DELEGATED DECISION

Item No.	Report of the Head of Development Management and Building Control	
Address:	14 WILLOW TREE LANE HAYES	
Development:	Change of use from Class C3 dwelling house to 7-bedroom / maximum 8 person HMO Use Class Sui Generis	
LBH Ref Nos:	5516/APP/2025/2441	
Drawing Nos:	HD00257 - PL06 HD00257 - PL05 HD00257 - PL07 HD00257 - PL08 HD00257 - PL09 Design and Access Statement HD00257 - PL01 HD00257 - PL02 HD00257 - PL04 Noise Impact Assessment, 28th October 2025, Dice Environmental Acoustics Transport Assessment, October 27, 2025, Nene Valley Transport Planning Parking Survey Report, October 24, 2025, Nene Valley Transport Planning	
Date Plans received:	19-09-25	Date(s) of Amendments(s):
Date Application valid	19-09-25

Planning permission is sought for the Change of use from Class C3 dwelling house to 7-bedroom / maximum 8 person HMO Use Class Sui Generis.

HD00257 - PL05B

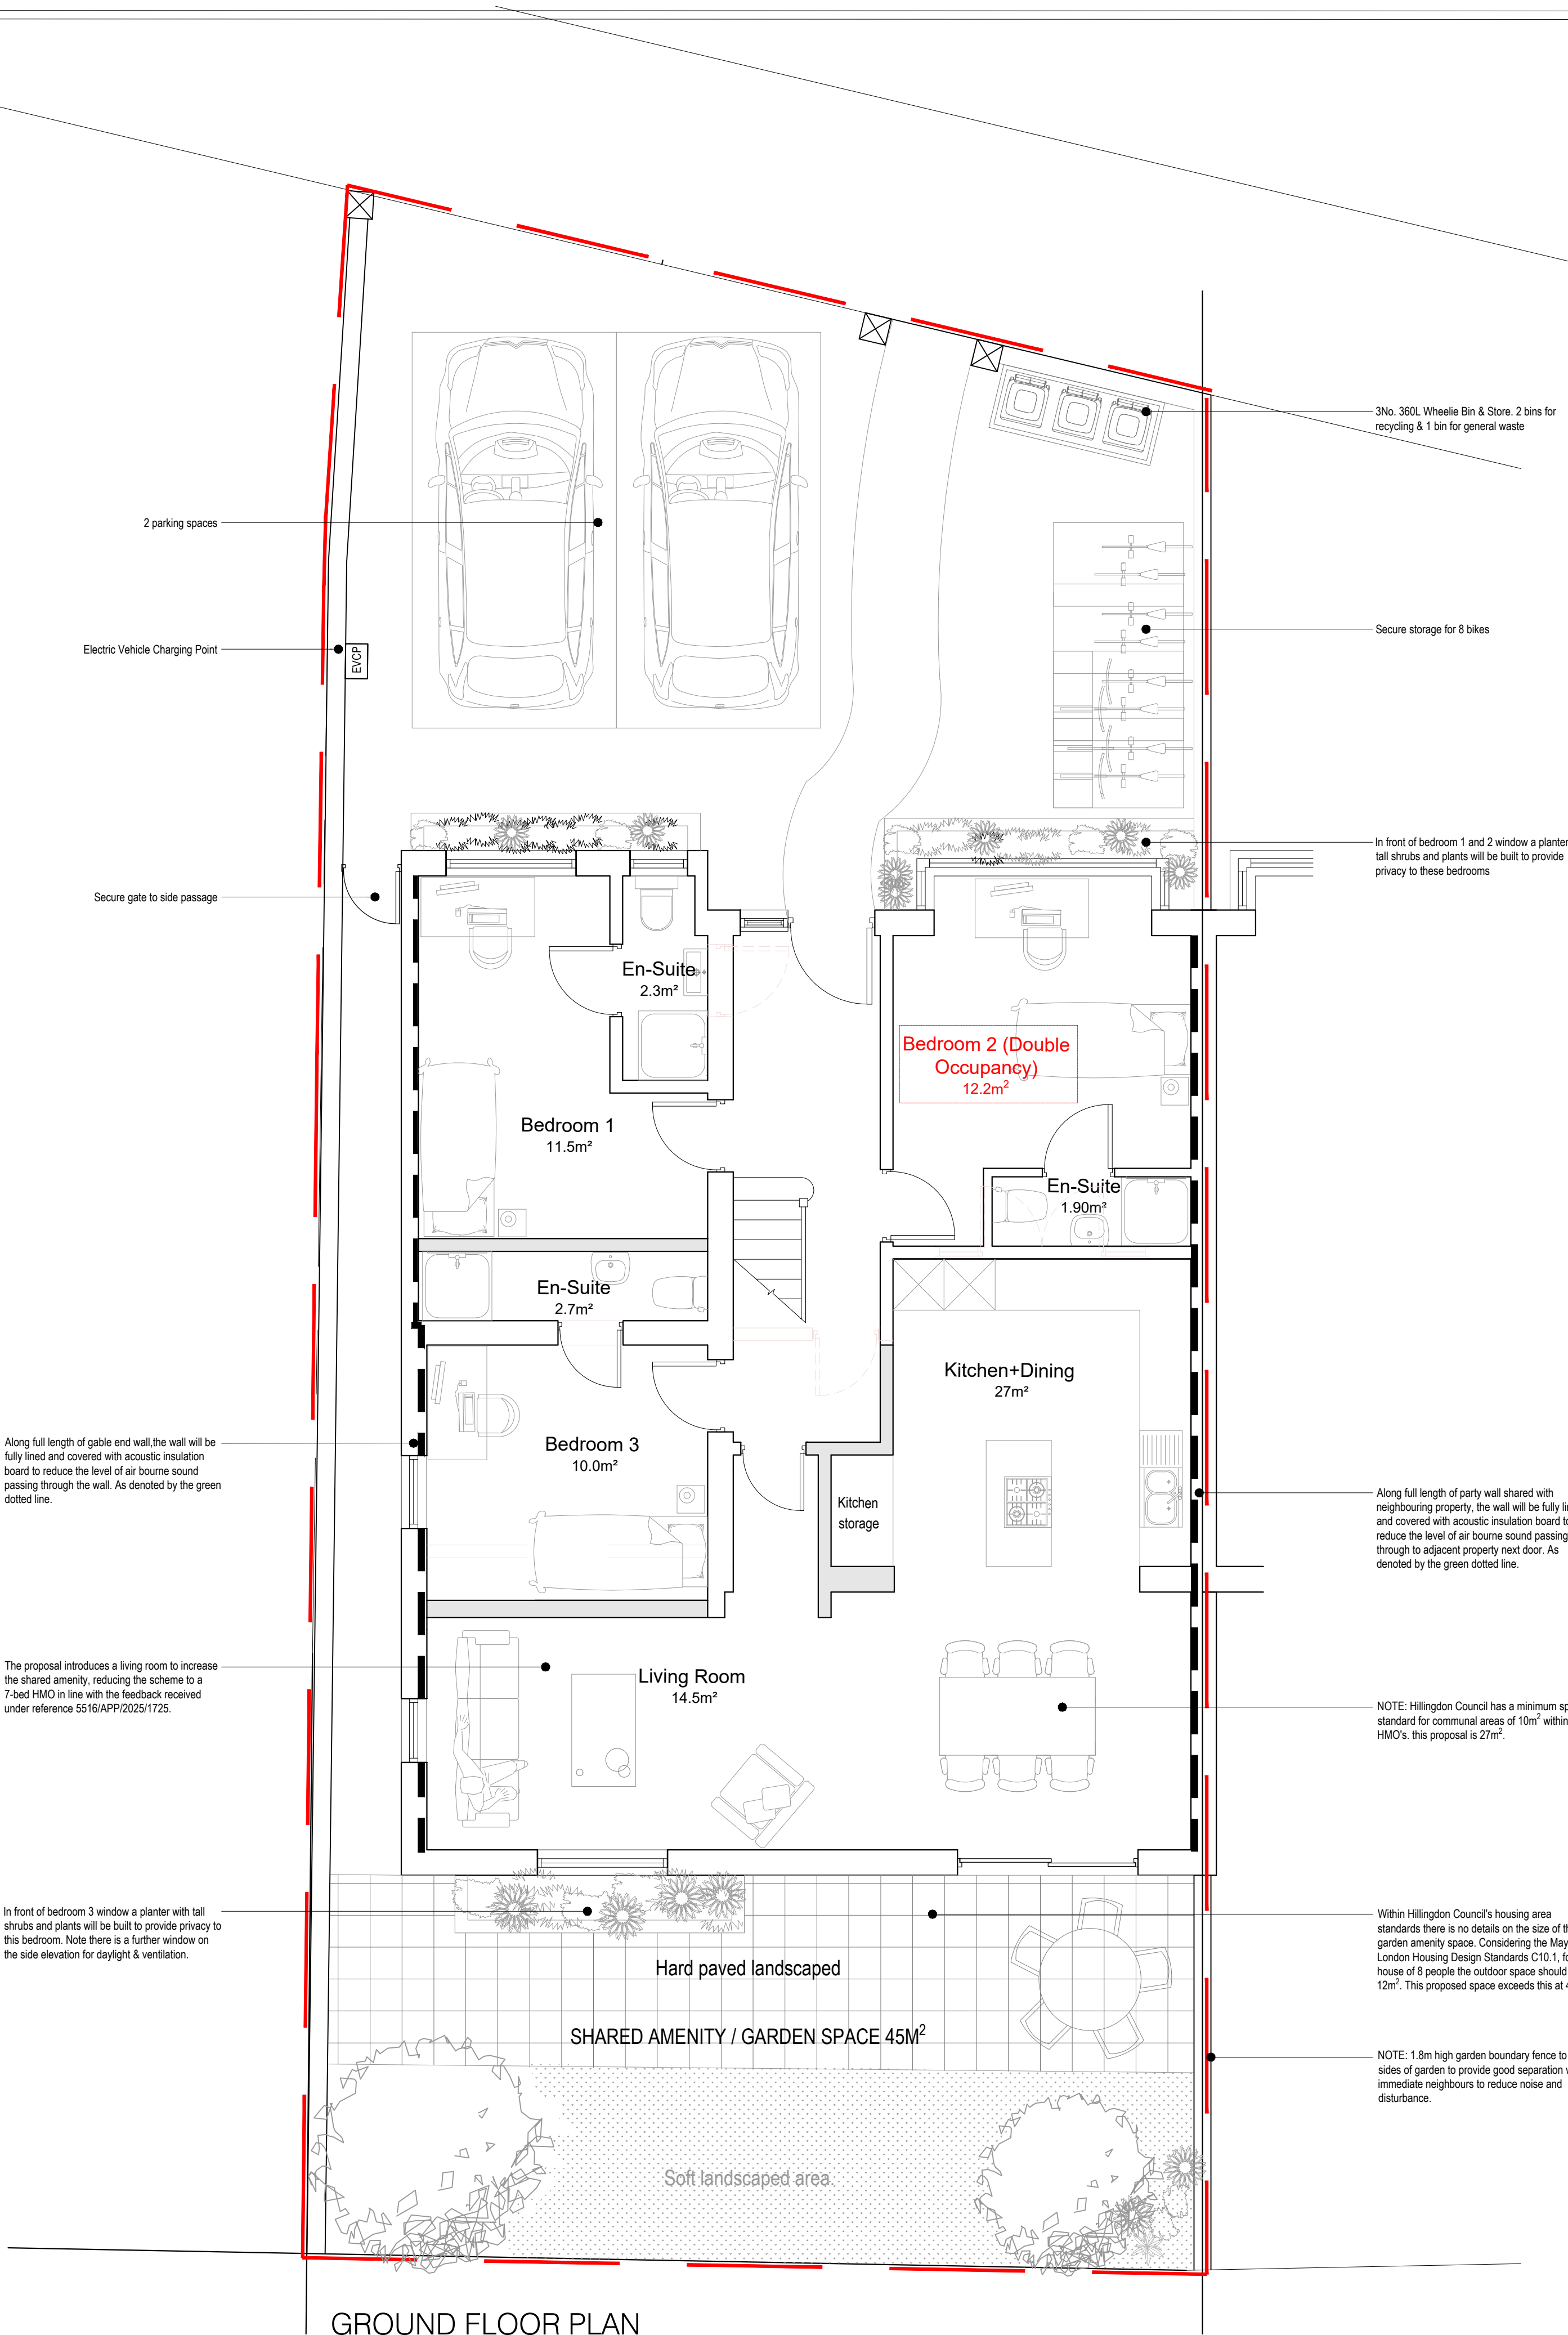
Bedroom 1: 11.5m²

Bedroom 2: 12.2m² (double occupancy)

Bedroom 3: 10 m²

The bedrooms are all en-suites. Whilst only one of the bedrooms is denoted as being intended for double occupancy, four of the bedrooms would qualify as double rooms due to being over 11.5sq.m in size

The proposed development could result in 11 people living at the site on a permanent basis (as 4/7 rooms are double rooms). Notwithstanding the application form describing a maximum 8 person HMO, it is considered that 8-11 people moving in and out of the site, on a regular basis, by foot, car or bicycle would cause a significant increase in activity at the site to the detriment of neighbouring amenities. The likelihood of nuisance and disturbance to neighbours amenities would also be increased by the over intensification of the sites use. Use of the sites garden space for such a high number of people, alongside potential visitors, would generate noise over and above that of the existing family house, such noise would be detrimental to all of the sites adjoining neighbours.

Concerns were previously raised in the consideration of application reference 5516/APP/2025/686 with regards to the privacy of Bedrooms 1 and 2 which are located on the ground floor given the only outlook from the windows would be directly facing the front driveway and would be overlooked

It is however noted that the ground floor window serving 'Bedroom 3' on the ground floor side elevation would face directly onto the boundary treatment at close proximity. The occupiers of this room not be provided with adequate levels of outlook and daylight due to the obscure glazing that would be required for the lifetime of the development. This is considered to warrant a separate reason for refusal.

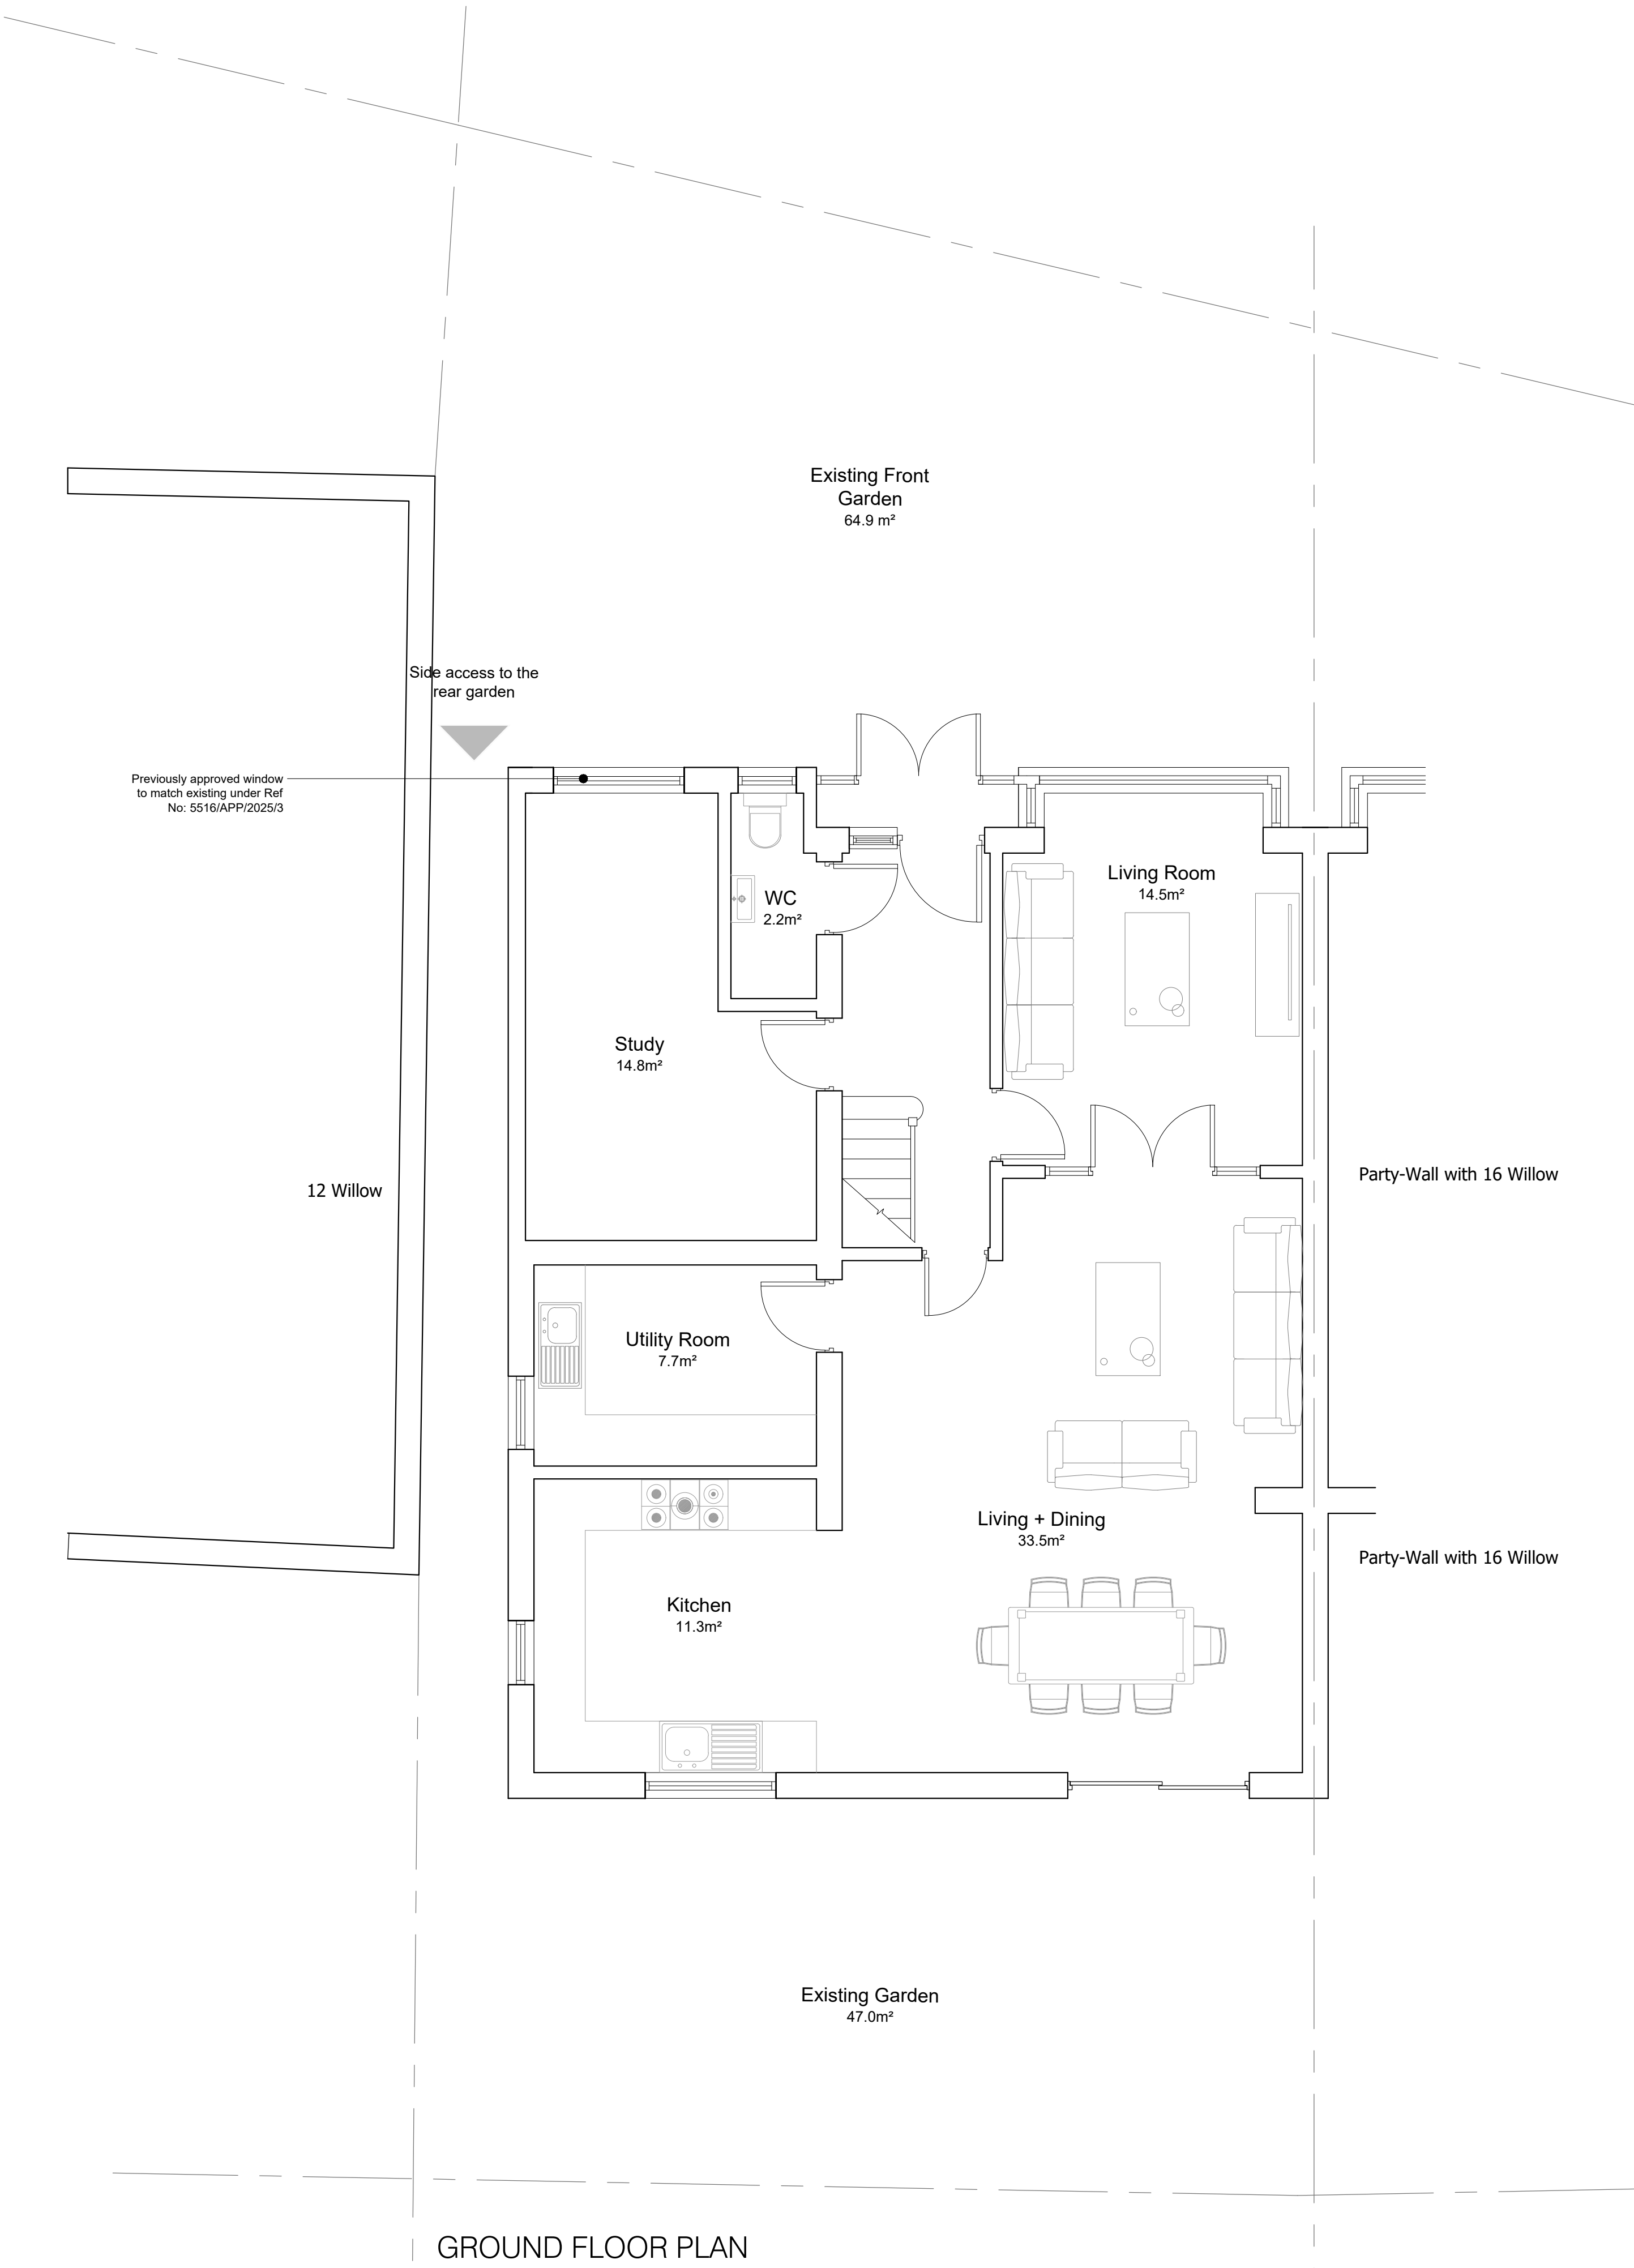
Whilst the HA accepts the provisions outlined in the TS, the proposed forecourt layout remains extremely constrained. It attempts to accommodate two car parking spaces, sheltered bicycle storage for eight cycles, and refuse bins within a limited area. Swept path analysis indicates minimal tolerance for vehicle movements, particularly when entering the forecourt, which will require reversing and could involve multiple manoeuvres. This poses a risk of obstructing traffic along Willow Tree Lane, especially buses near a busy junction.

Current guidance requires a minimum of 6 metres of clear space in front of parking bays; however, the proposed layout does not provide sufficient clearance for vehicles to enter in forward gear. Consequently, vehicles may need to reverse repeatedly to access bays, creating potential hazards for pedestrians and causing delays to traffic, particularly buses.

Furthermore, the TS does not include dimensions on the submitted plans to demonstrate compliance with key standards, such as parking bay sizes, 6m clearance, and pedestrian path widths, despite previous HA requests.

Cycle parking must be covered, secure, and easily accessible in accordance with the London Cycling Design Standards (LCDS) and the London Plan. The current proposal fails to meet these requirements.

Moreover the proposal illustrates that there to be 2 spaces to be provided at the front of the site. These are heavily compromised by the proposed location of the cycle store which in accordance with the London Plan should provide 8 secured and covered cycle spaces. Swept path lines are illustrated on the site plan but clearly there would be a potential conflict between the vehicles entering and existing the site with the cycle store and bin store.
